Re: Local Planning Authority Reference EG/69/17/PL

**For: 4 No. live/work units, Research & Development propagation building & growing area, garden room, fuel store & greenhouse to main dwelling & formation of new access.
(Departure from Development Plan)**

At: Swallowfield, Eastergate Lane, Eastergate, PO20 3SJ

Drawing Live/Works Dwellings
Block A Units 1 & 2
Plan, Elevations & Section

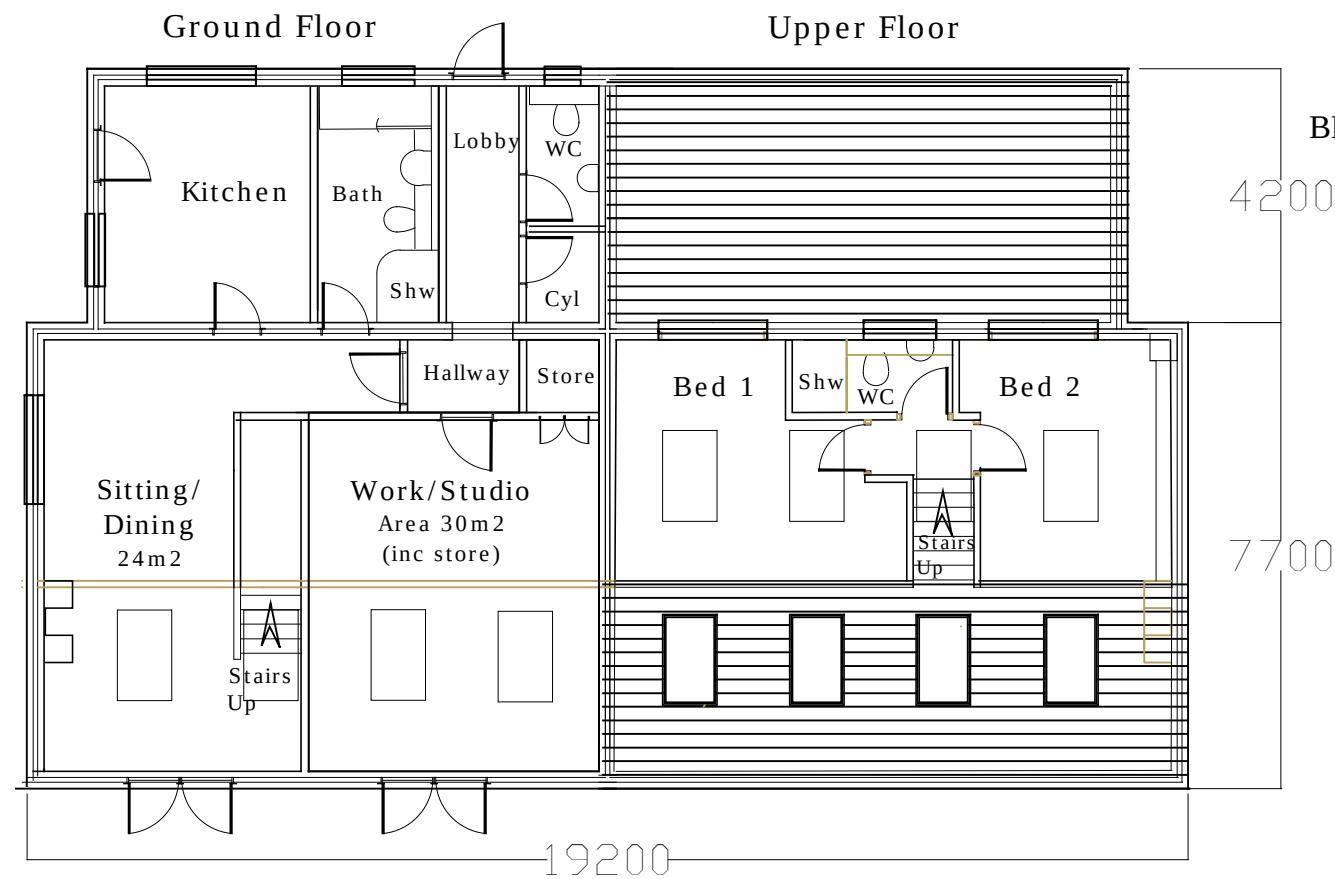
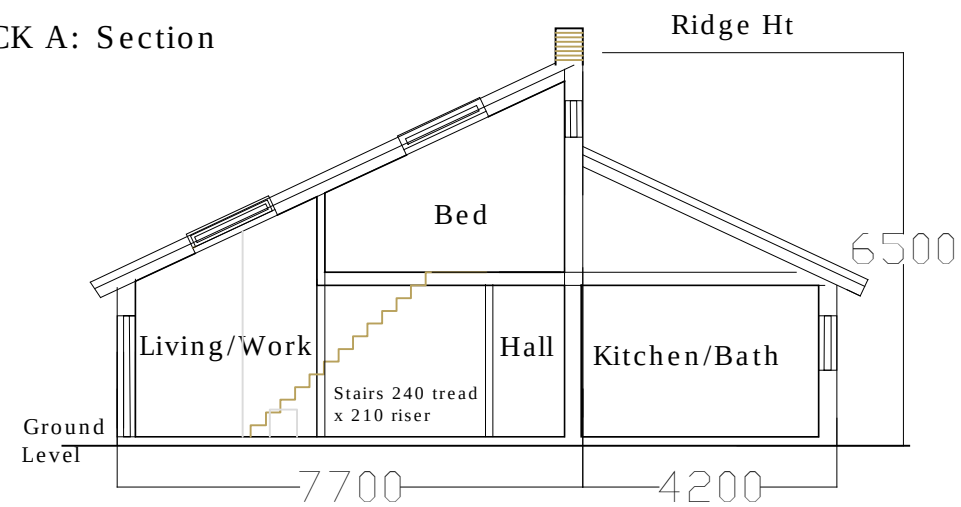
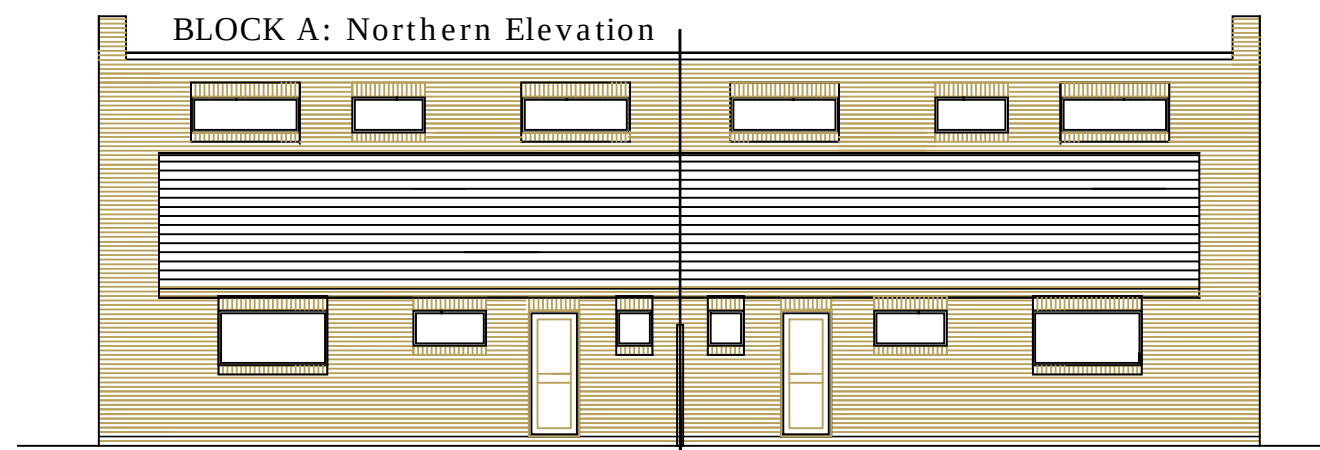
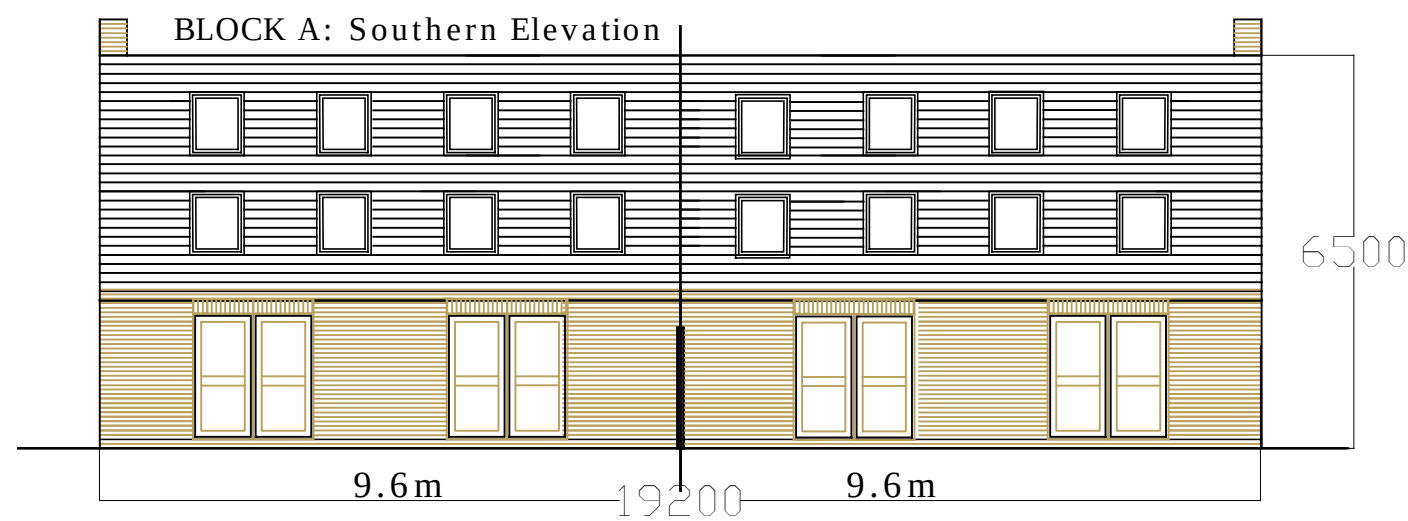
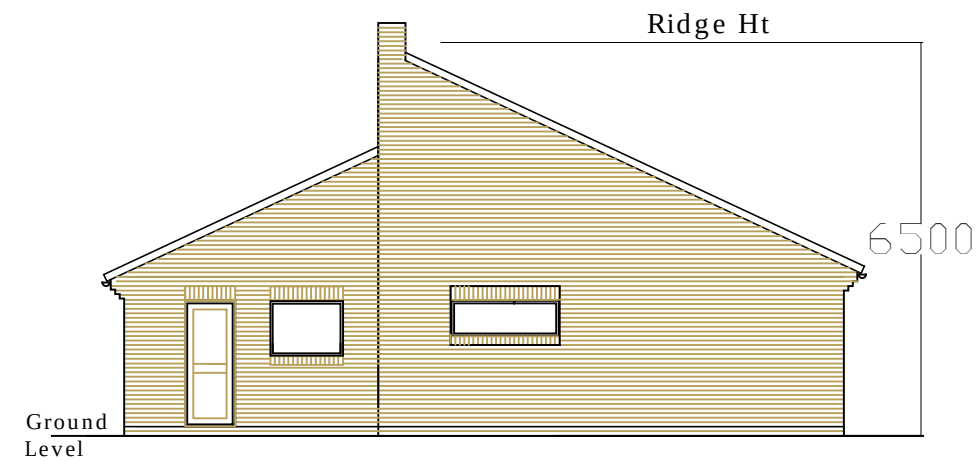
2. Community Character & Quality of Design: The proposed development form and built style is ugly and completed out of out of character with the existing urban grain and built form of the area. The work units proposed will sit within a residential area close to private residential properties that are all large and sit within substantial plots, whilst the proposed units are small and will sit within diminutive land parcels.

5. Visual Privacy: It is one thing for your private, domestic garden to be overlooked from first floor windows of other private residential properties. This is to be expected and provides only occasional views from non-living room areas that are not subject to intensive day time use. Even in the evenings, such windows would typically be screened by drawn curtains to protect the occupant's own privacy. In commercial premises, such first floor accommodation is typically office space and this is subject to intensive use throughout the day and often late into the evenings through into the weekends, dependent upon the nature of the business. This is obviously going to have a tremendously detrimental and adverse impact upon the privacy of our home reducing substantially not only real levels of existing privacy but also substantially increasing the feeling of being overlooked and supervised on an intensive basis.

Drawing: Proposed Site Development  
Layout  
For: Swallowfield Nursery  
CHICHESTER PO20 3SJ

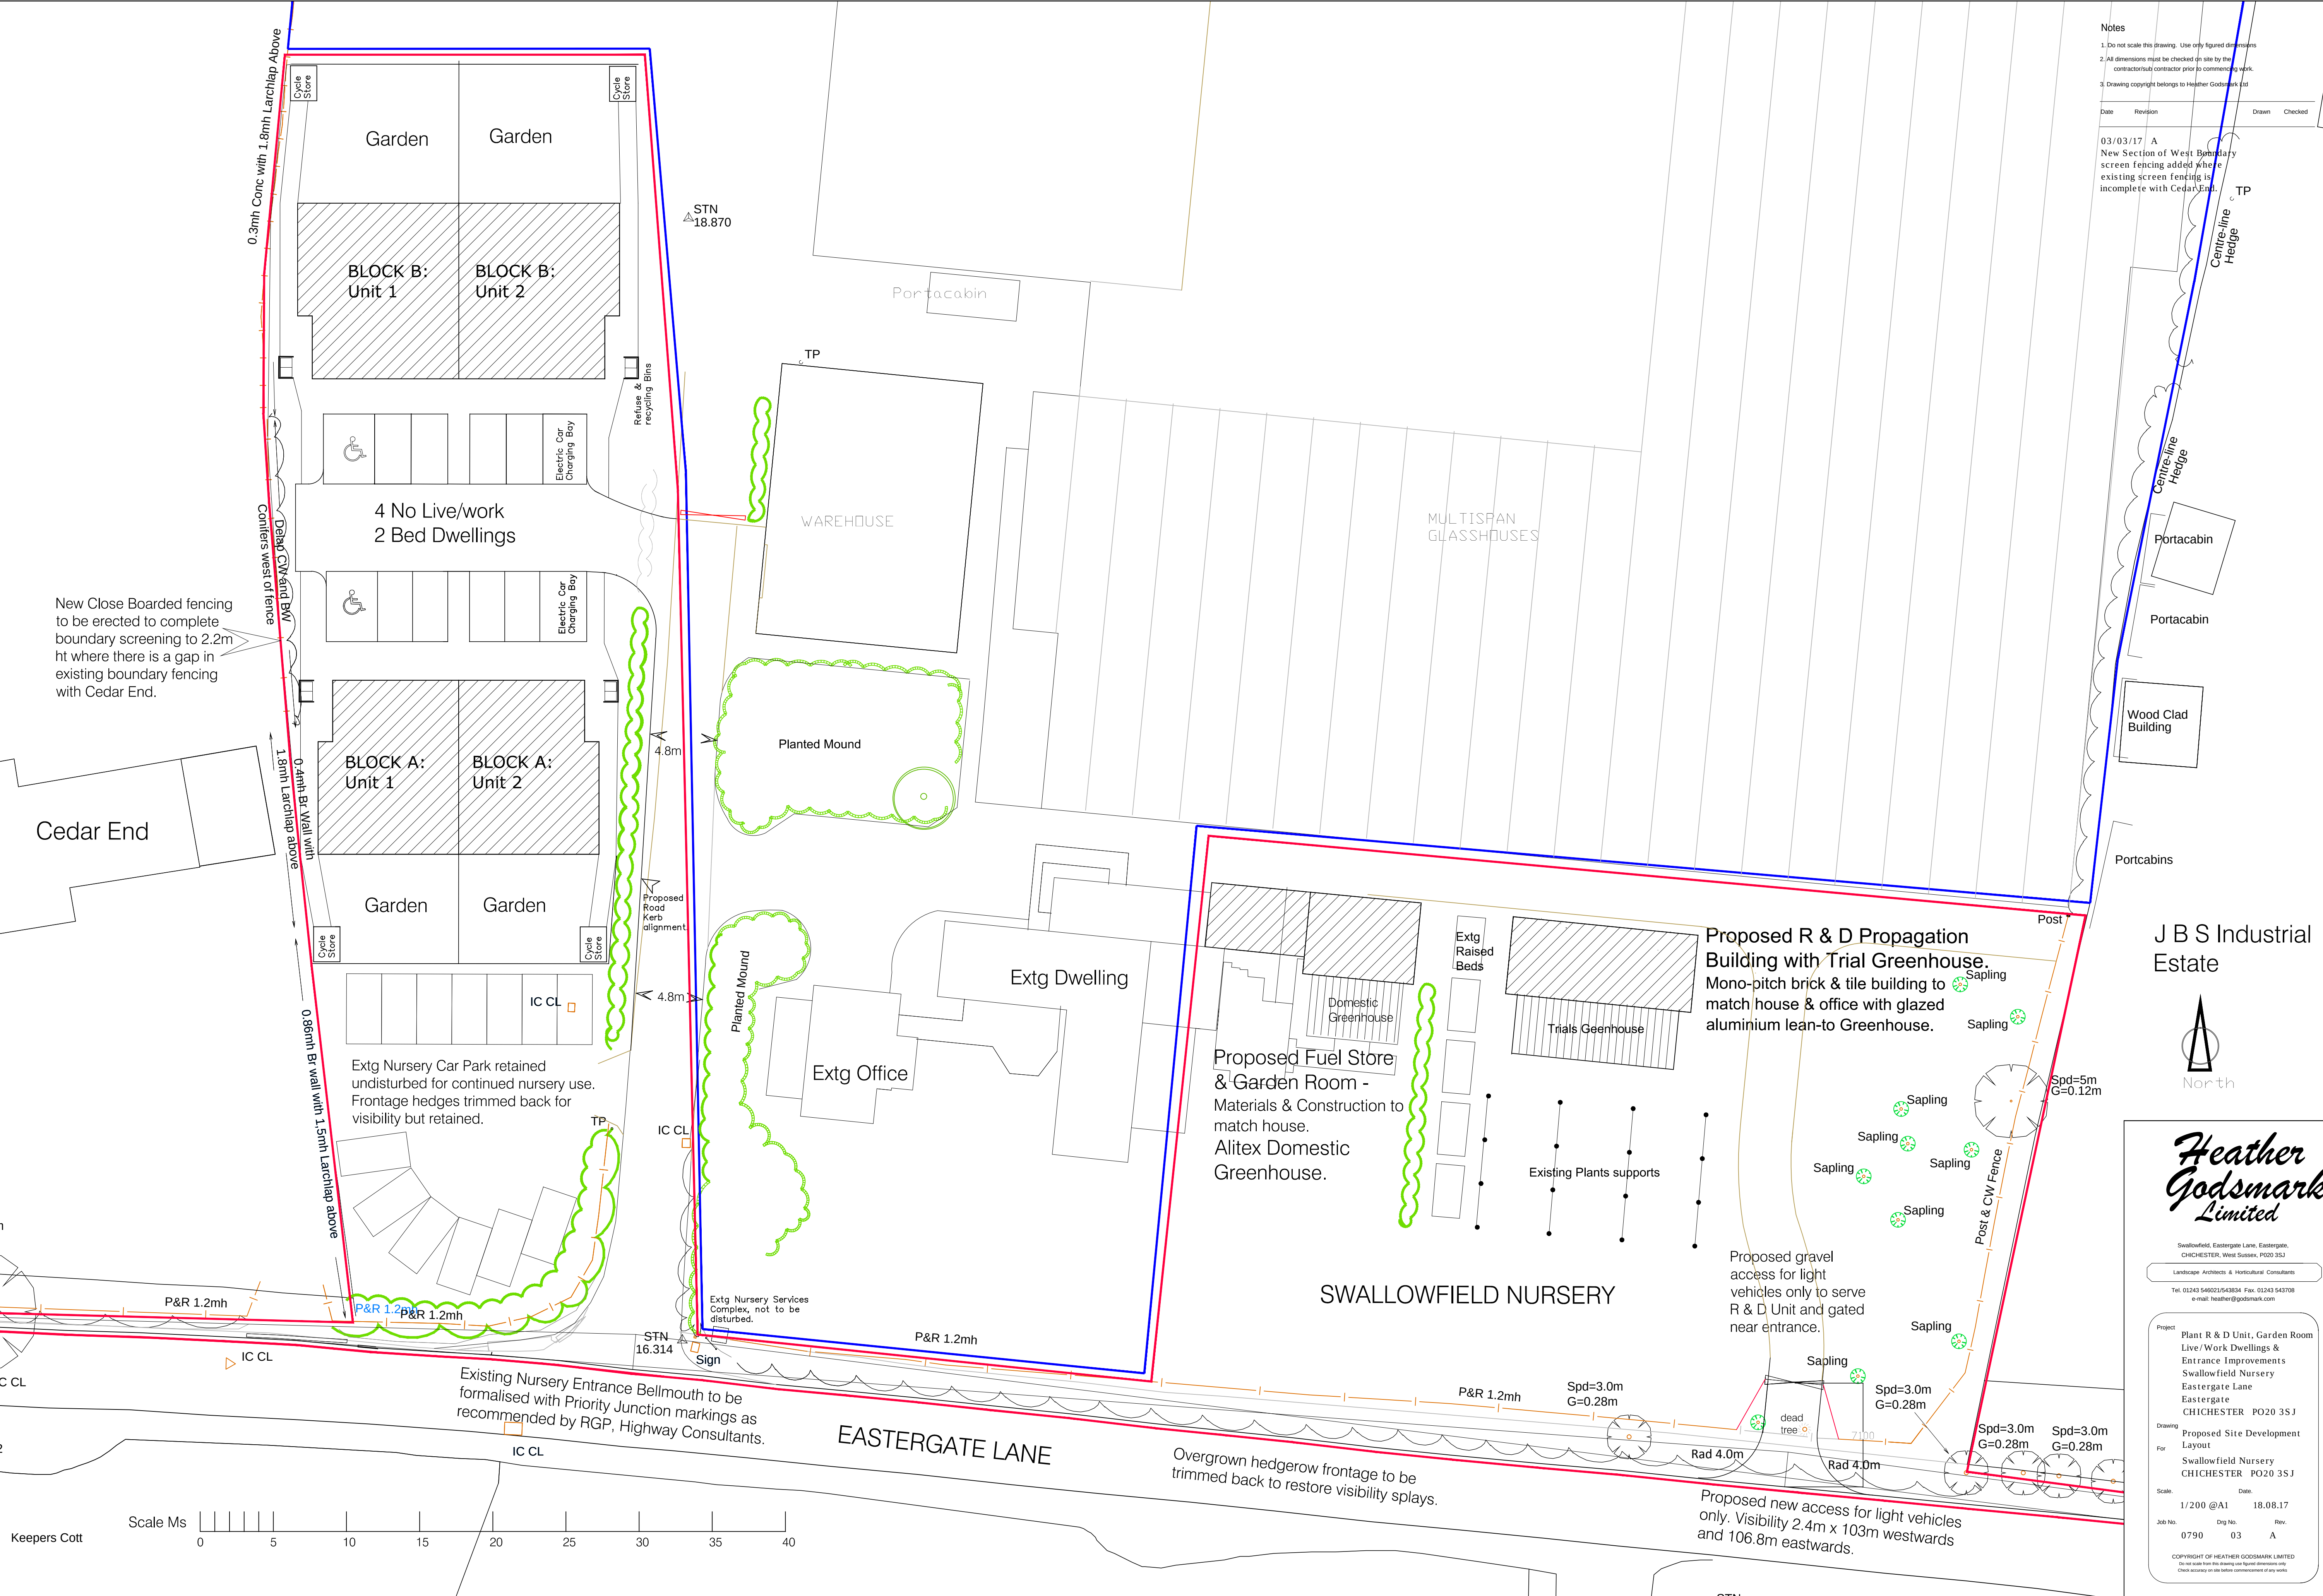
3. Proximity: At their nearest the proposed units will sit within just one metre of my private garden boundary. This is not even enough distance to have meaningful boundary landscaping, provide clear access between the new building and such planting and maintain a reasonable separation to ensure commercial activity is not within an intrusively close distance to the private garden boundary.
